29 FLORIDA STREET  
SYLVANIA (SSD-83258708)

RESPONSE TO SUBMISSIONS

REVISION 04

26.03.26

TYPICAL APARTMENTS -
MARKET BUILDING 1C

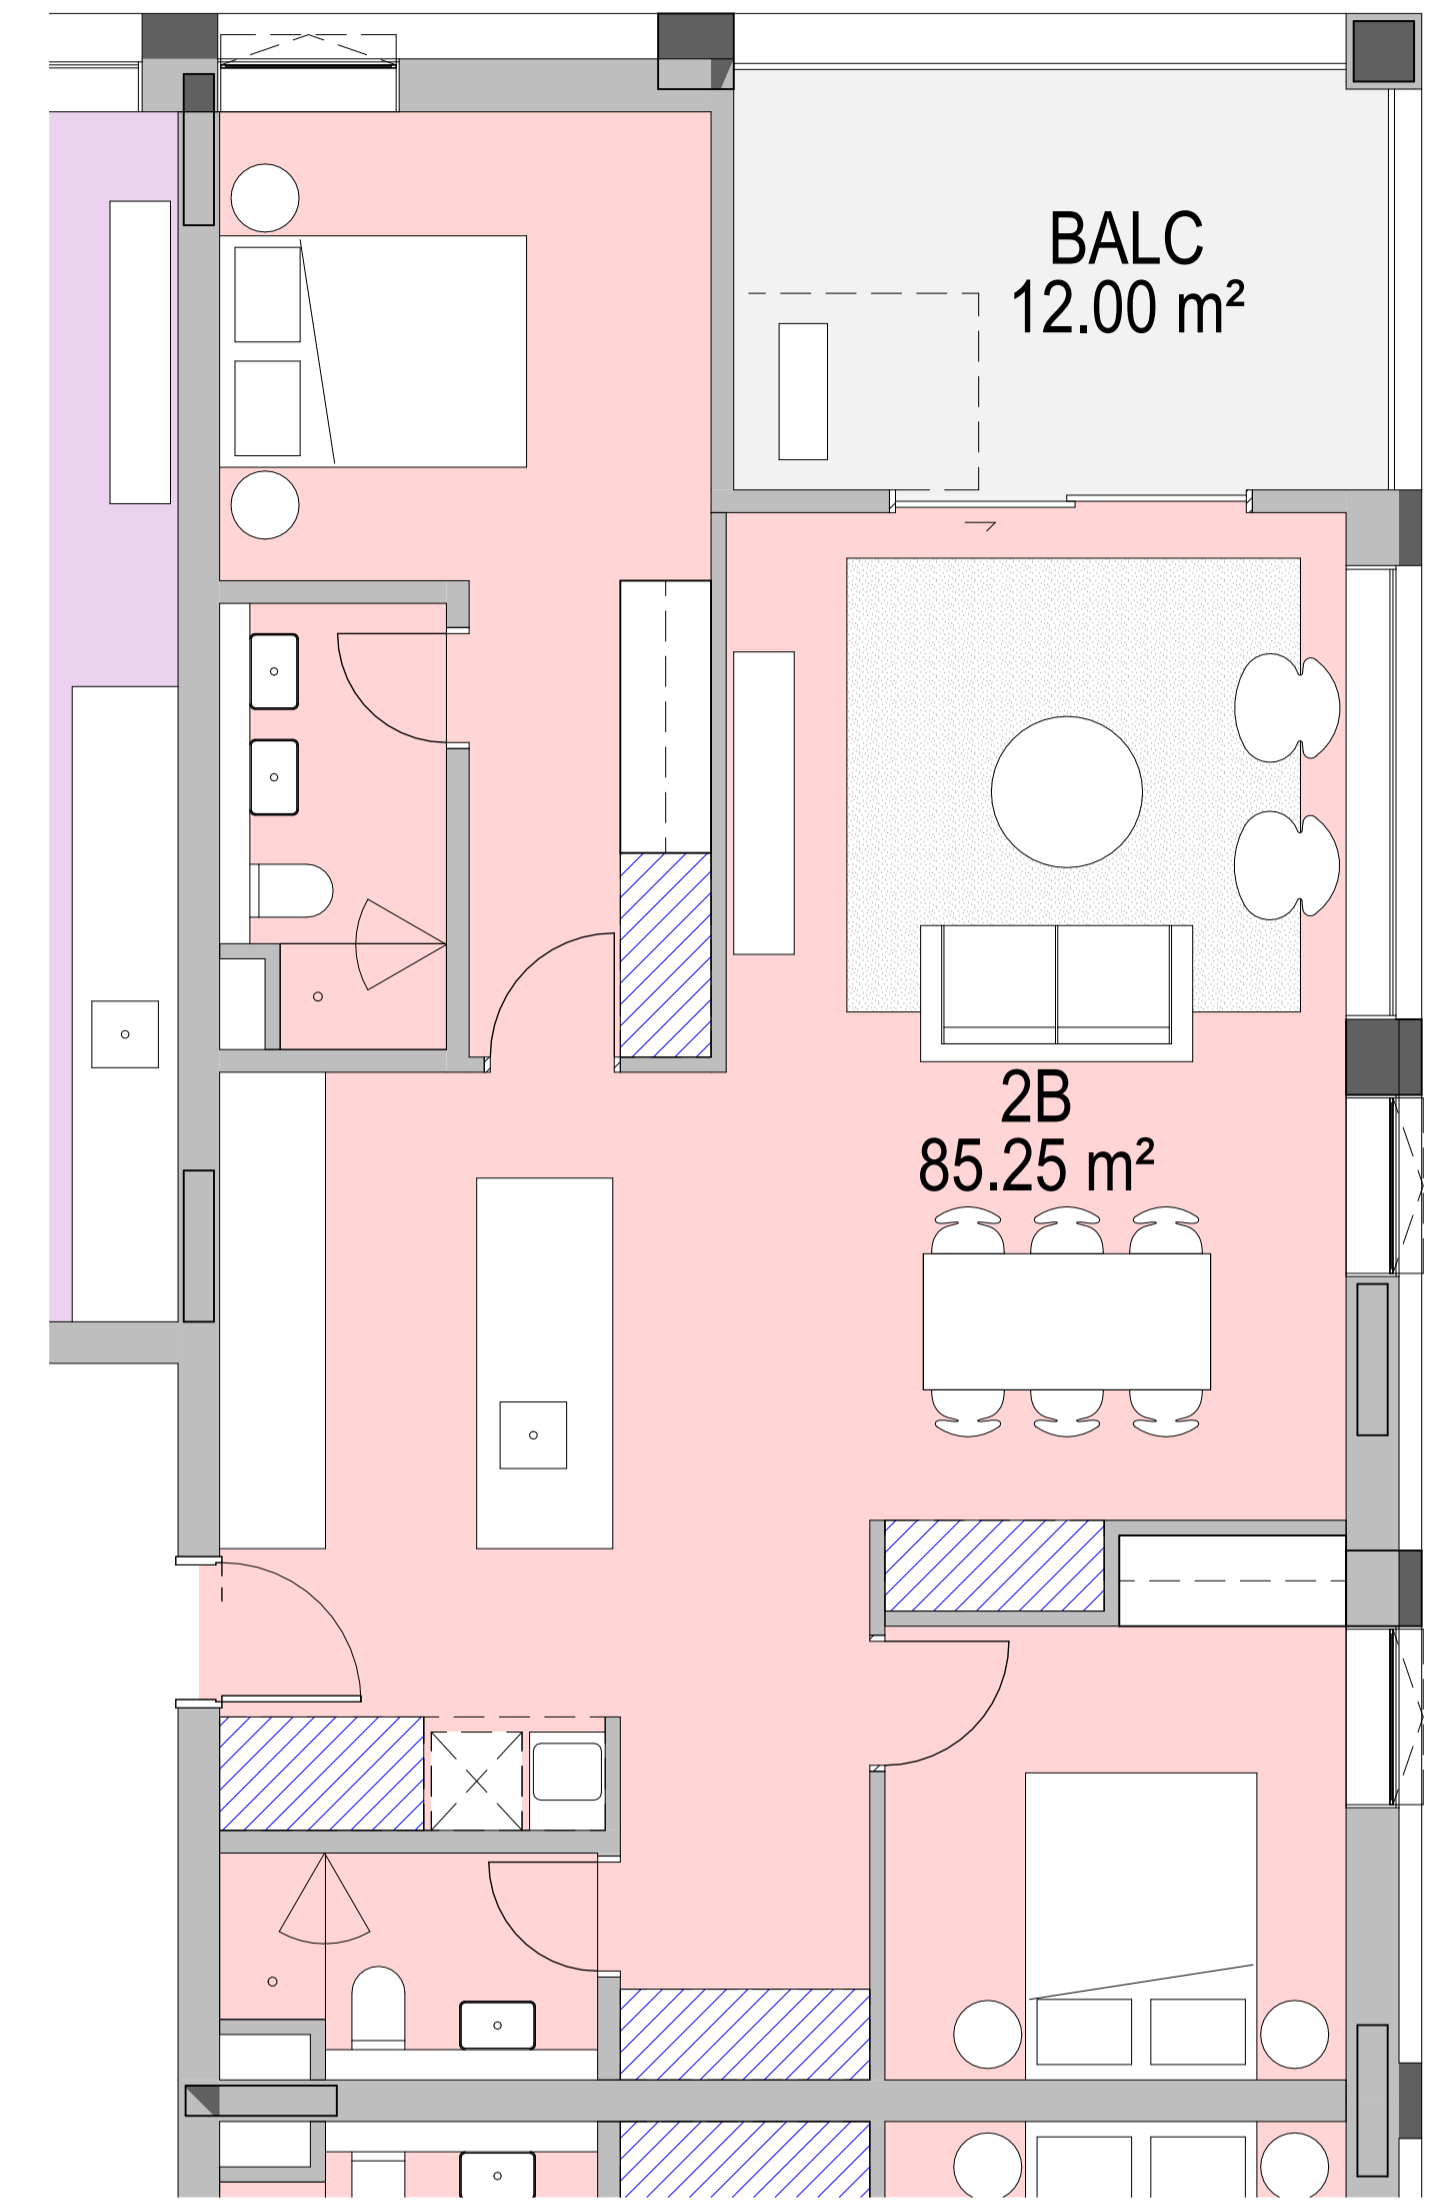
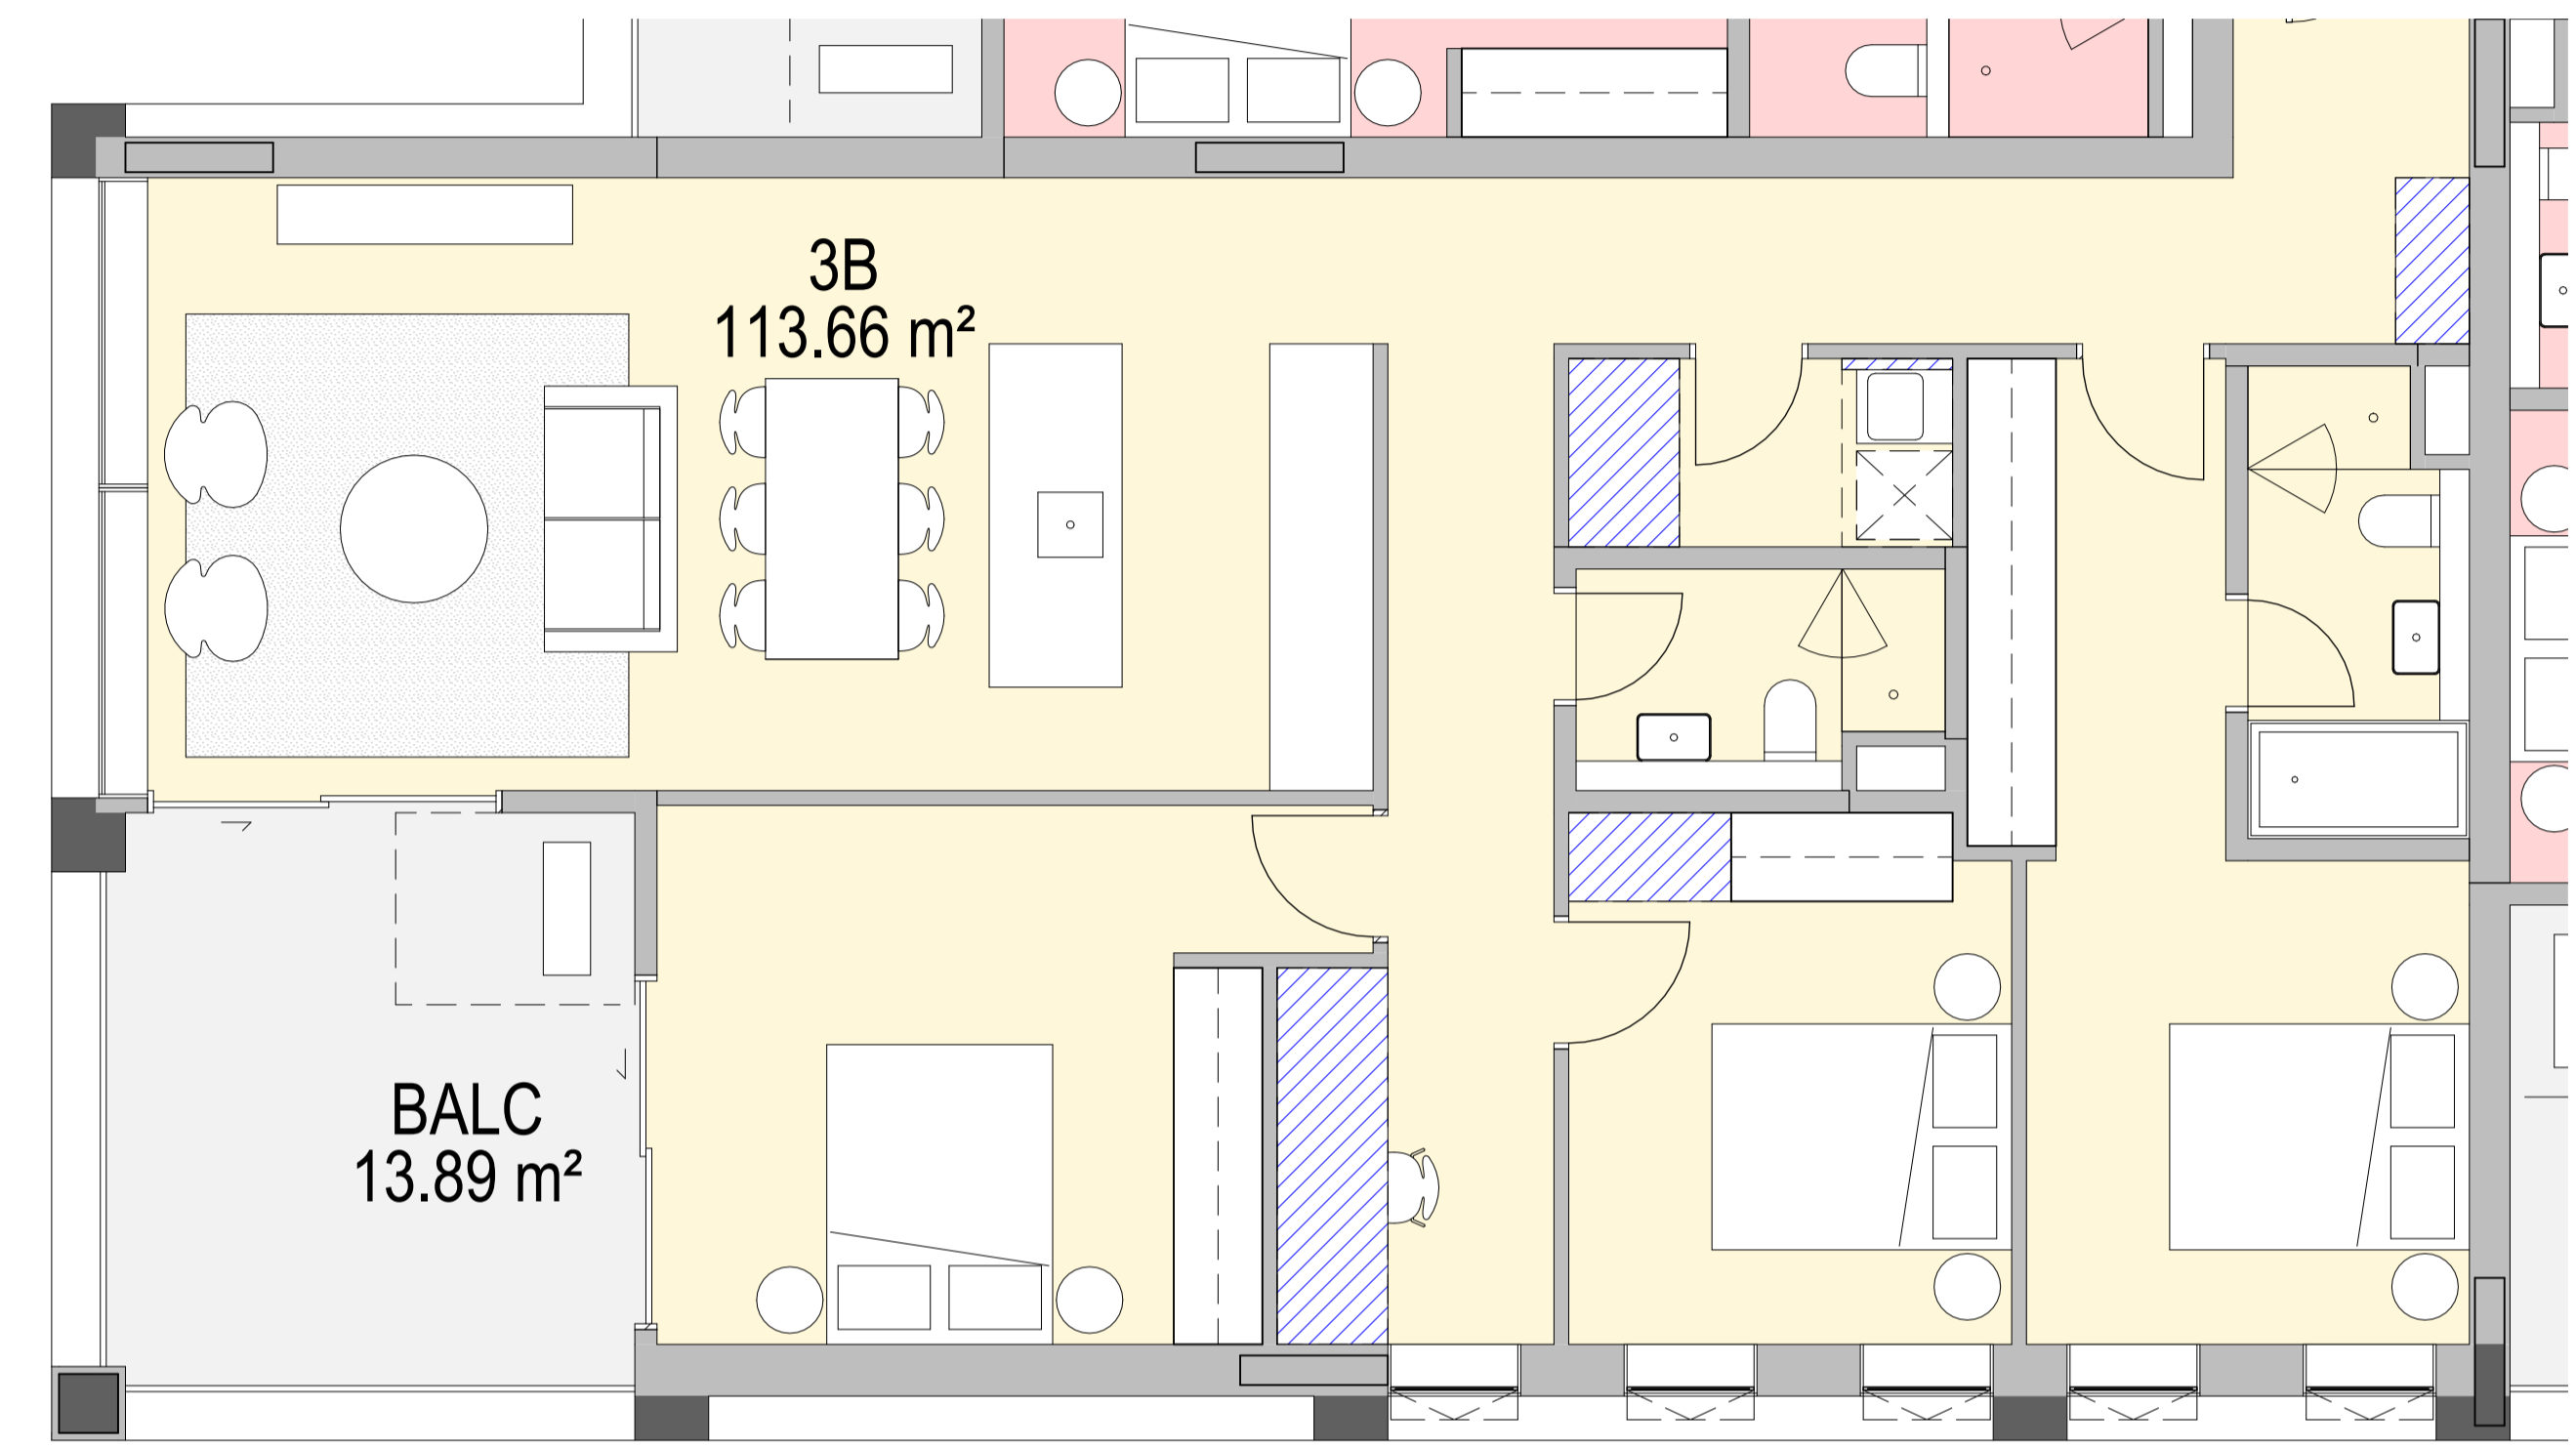
NO.	ISSUE RAISED	RESPONSE
BUILT FORM & URBAN DESIGN		
5.4	Provide annotated dimensions on plans that demonstrate all apartment sizes and layouts, and private open space areas are functional and provide a high standard of amenity having regard to the relevant design criteria of Part 4 of the ADG, specifically, Part 4D and Part 4E.	Annotated dimensions have been shown on plans for typical apartments below.
